DRAINAGE LETTER REPORT

CRAWFORD APARTMENTS
TRACT A, FOUNTAIN VALLEY RANCH FILING NO. 6B

October 17, 2022

PPR-2257

DEVELOPED
DRAINAGE PLAN

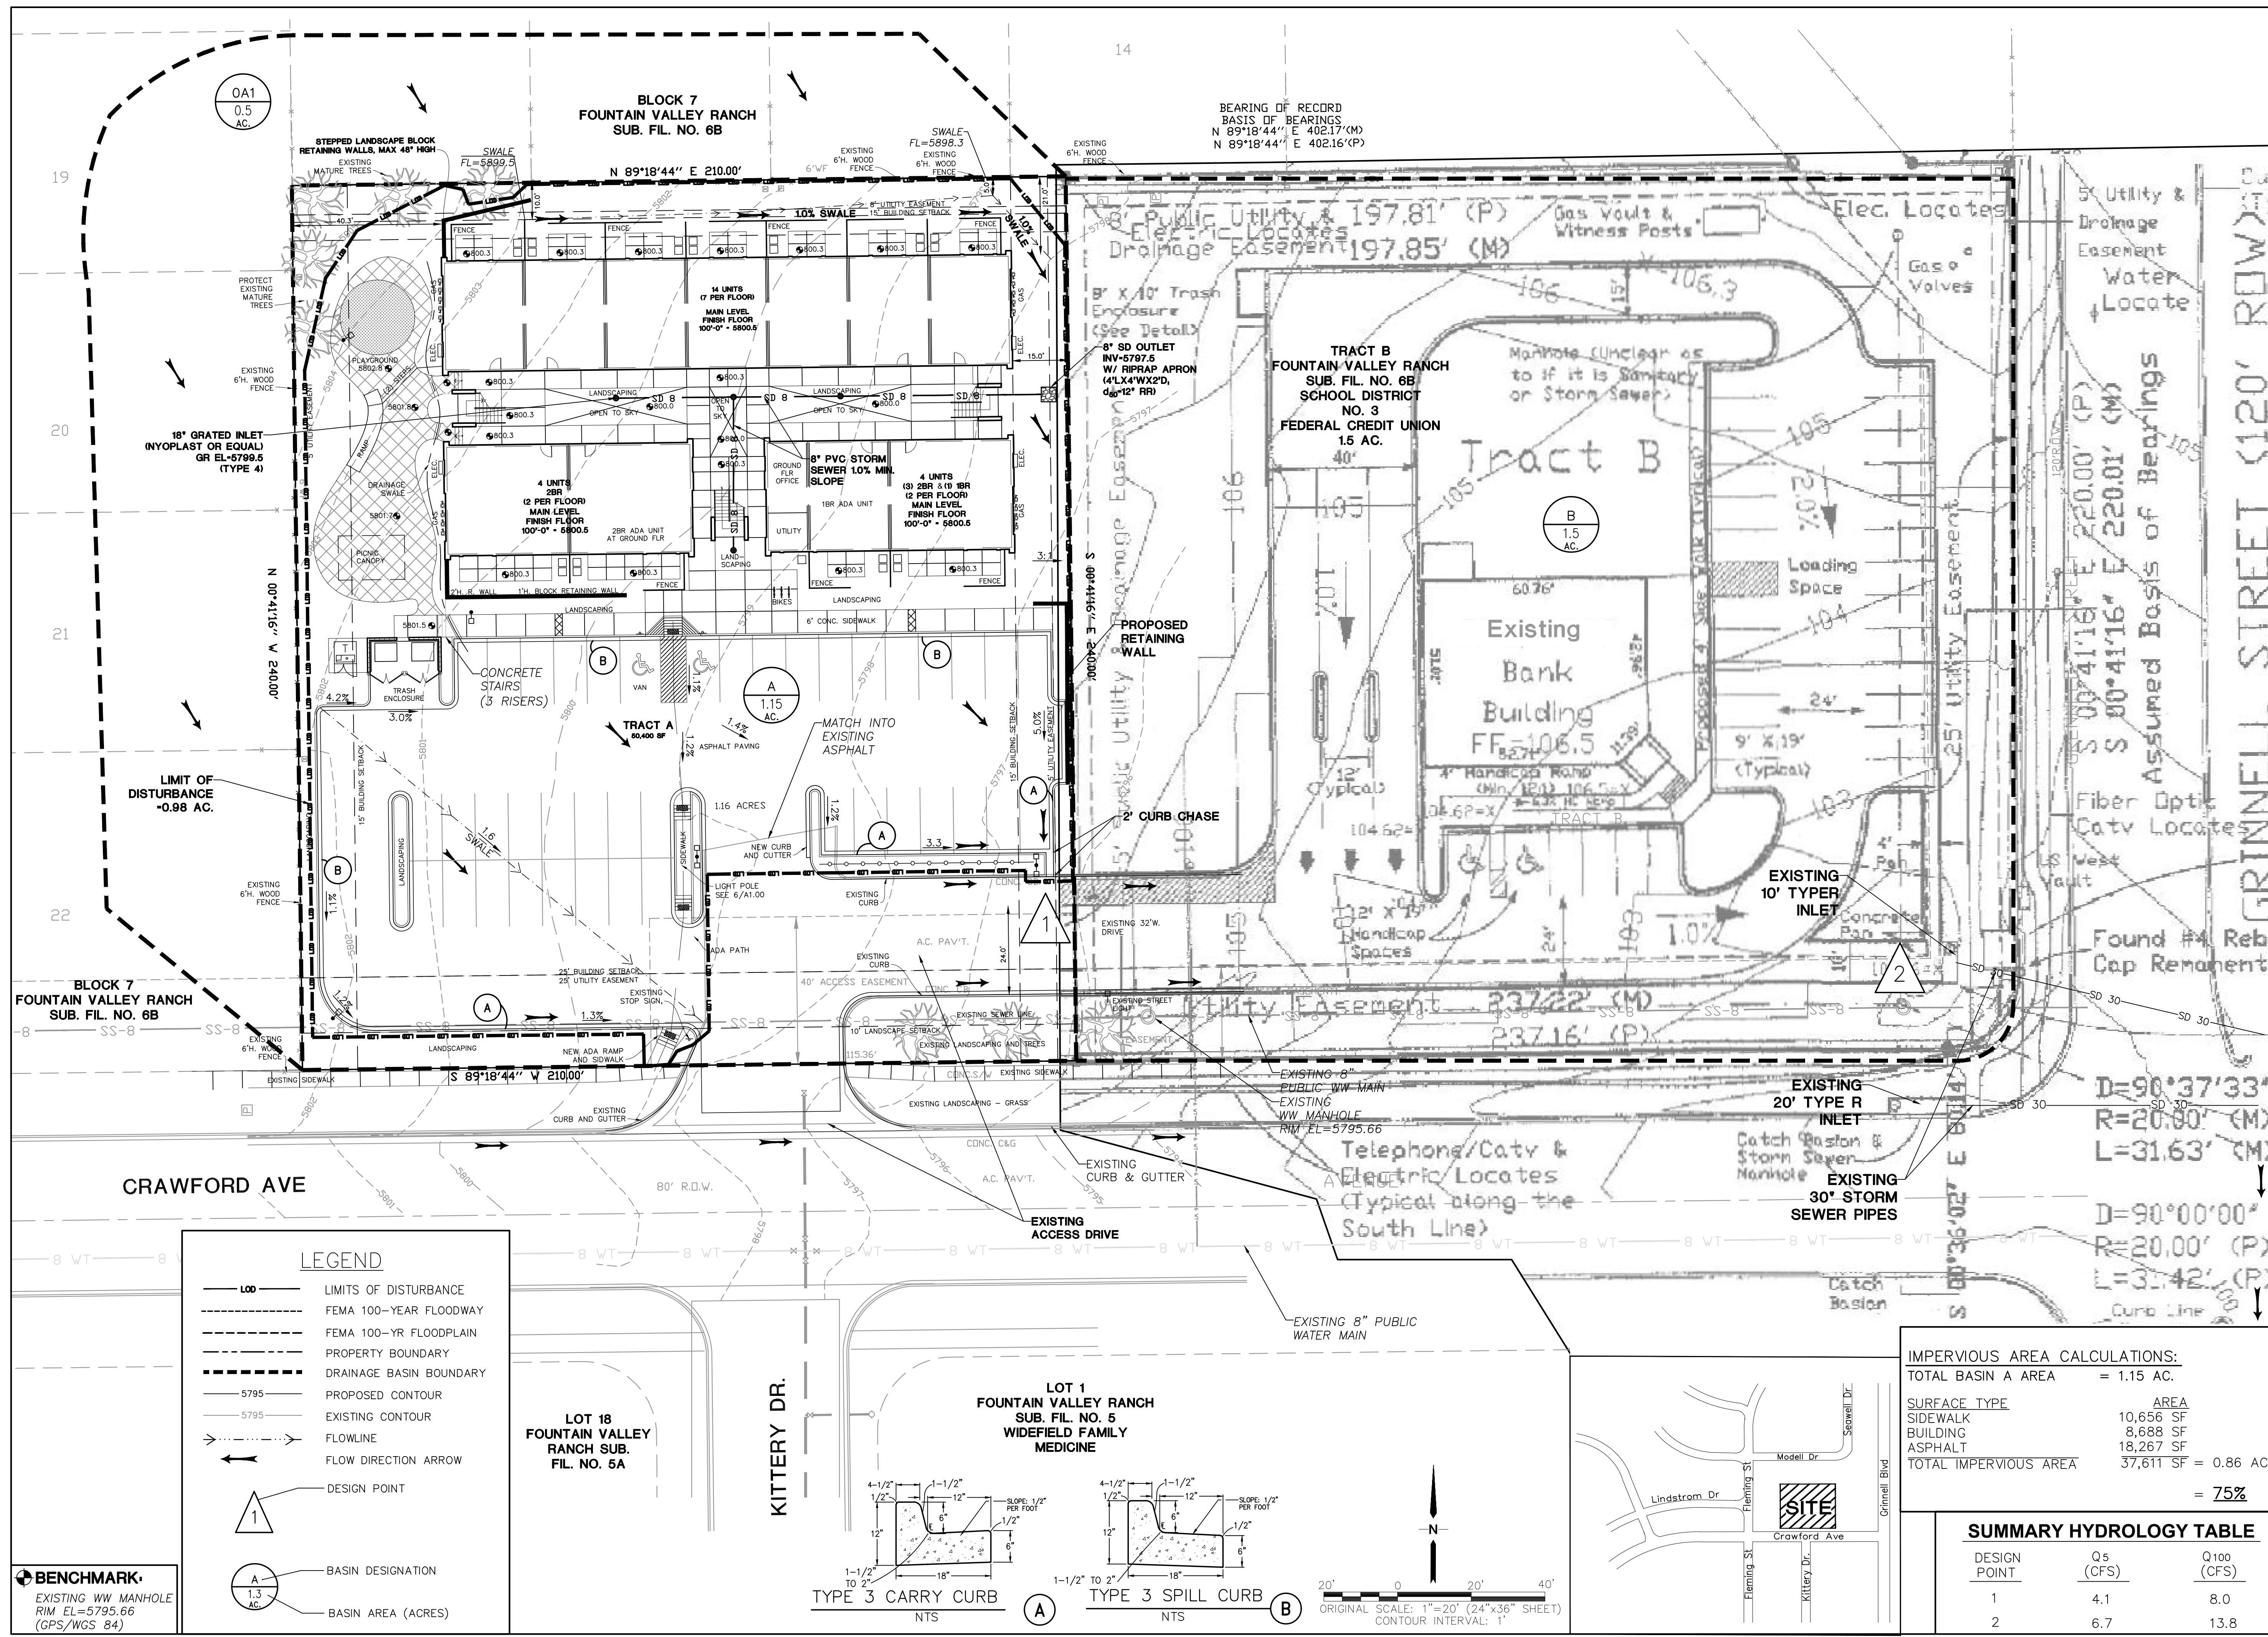
Stormwater collected by storm sewer and discharged onto adjacent property will not flow to DP1. Downstream impacts need to be addressed in this drainage report.
